Application by National Grid Electricity Transmission Plc for an Order granting Development Consent for the Richborough Connection Project

Planning Inspectorate Reference No: EN020017 Richborough Connection Project

Representation No. 14

Assessment of Bird Collision Risk submitted by South East Water

2D Proposed South East Water Reservoir - Route Options Appraisal

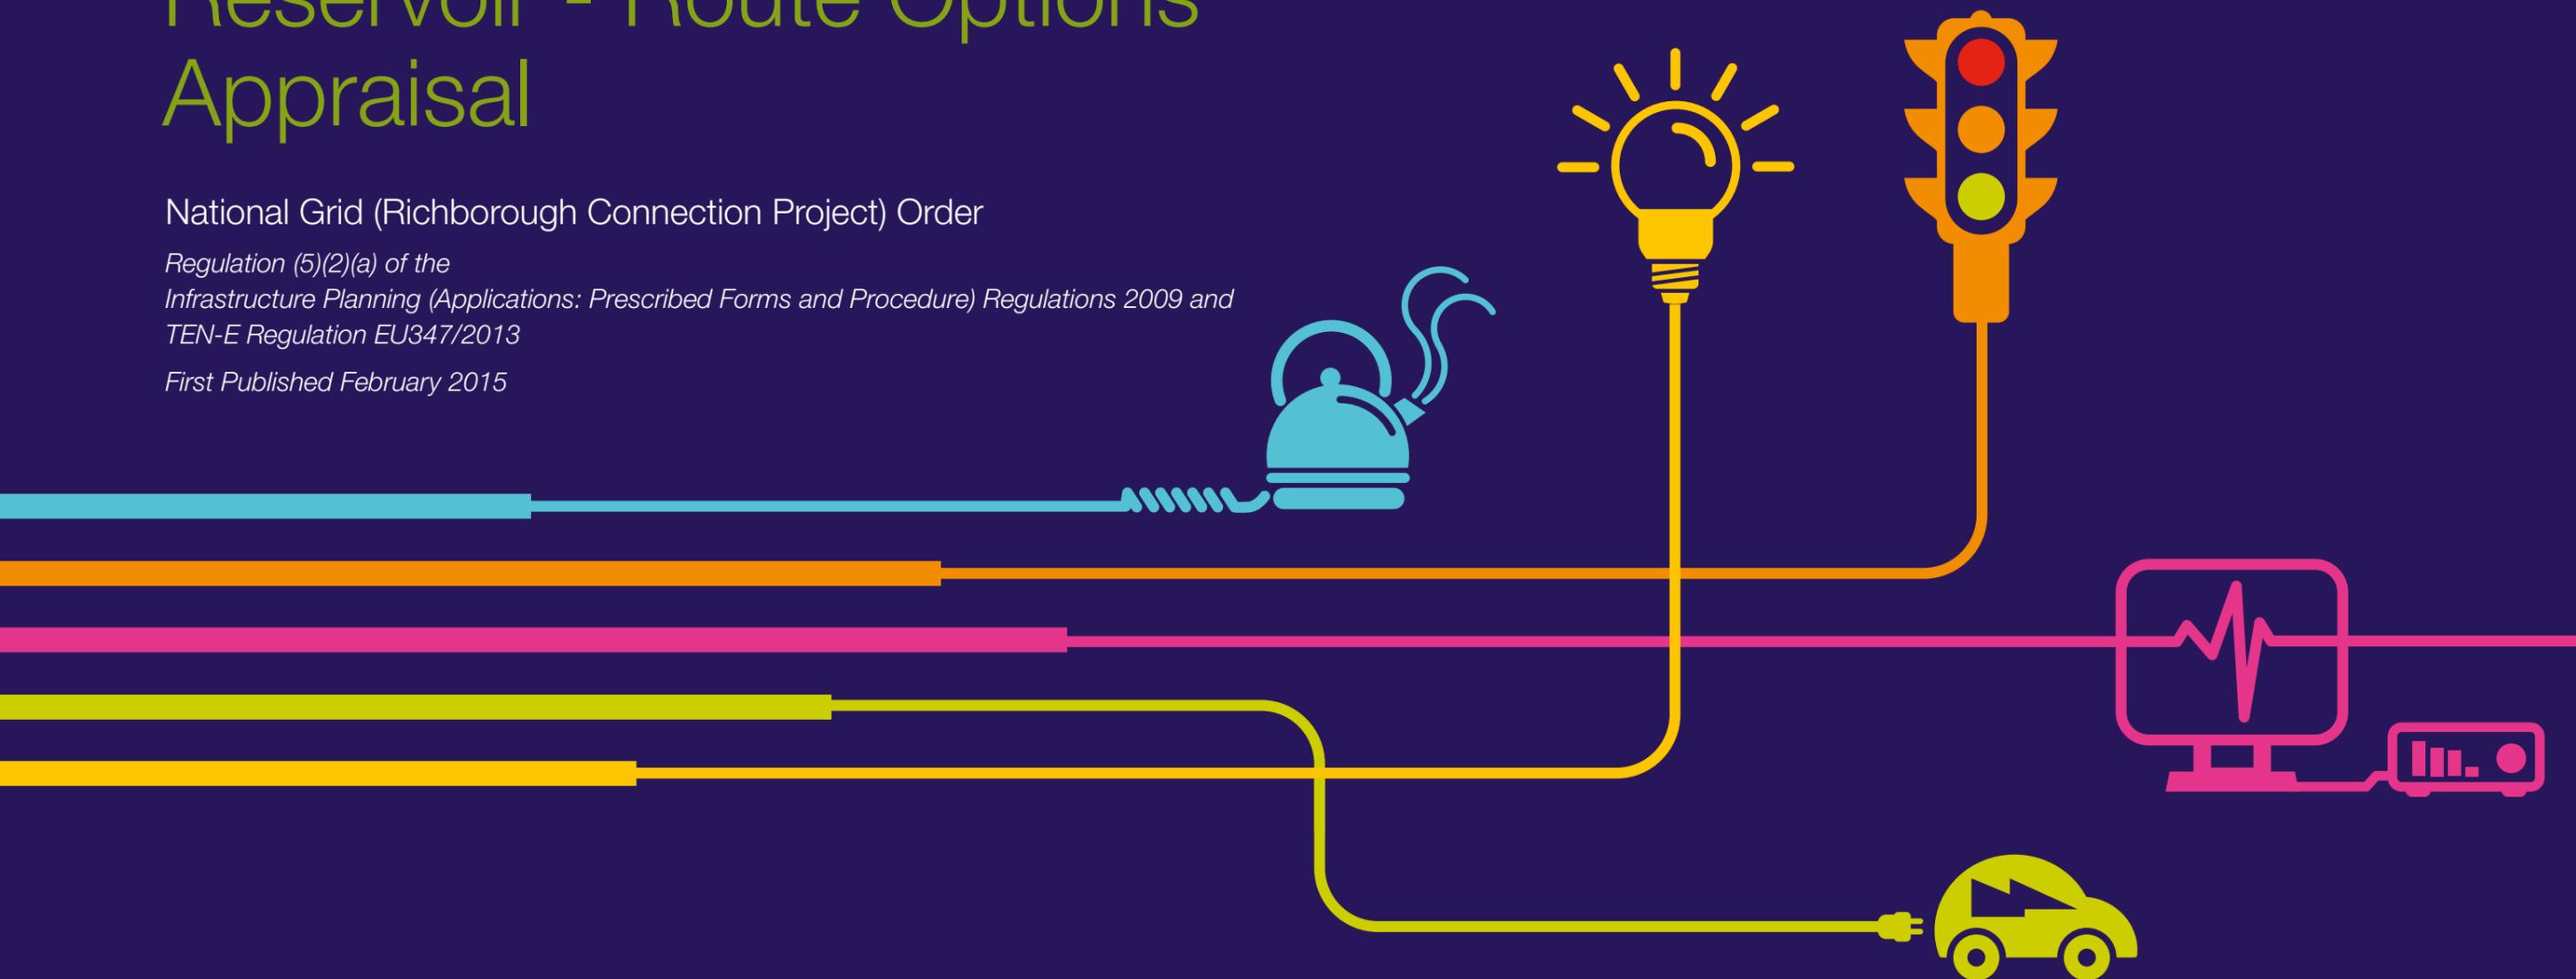
- 8 The current proposed route of the RCP lies very close to the proposed reservoir at Broad Oak. At the 36m AOD level, the RCP runs along the side of the reservoir (within 250m) for one kilometre. In addition to this, the RCP crosses the river diversion corridor for the Sarre Penn, over sailing this area for 605m.

- 13 Along the eastern and southern aspects of the proposed reservoir, for a total distance of 1km, the proposed RCP will present a risk of bird collision for birds utilising the available habitats at the proposed reservoir. The risk of bird collision has not been assessed as part of the Environmental Assessment for the RCP. The Applicant has not provided an assessment of the environmental effects of the RCP on birds that will utilise the available habitats at the proposed reservoir either in terms of the impacts of the RCP in isolation or in combination with the existing 400kv overhead line. It is South East Water's view that this is a significant omission and is a failure by the Applicant to comply fully with the requirements of the Infrastructure Planning (Environmental Impact Assessment) Regulations 2009. The risks described need to be fully understood, and mitigation clearly identified and remedied, to ensure that both infrastructure projects can be delivered within the same corridor.

- 14 Further, an understanding of both the level of risk to birds, and the necessary mitigation measures, should be available to the Examining Authority. If bird risk is such that a planning permission for the reservoir could not be granted unless a section of the RCP were undergrounded in order to satisfy the planning authority and Natural England that significant
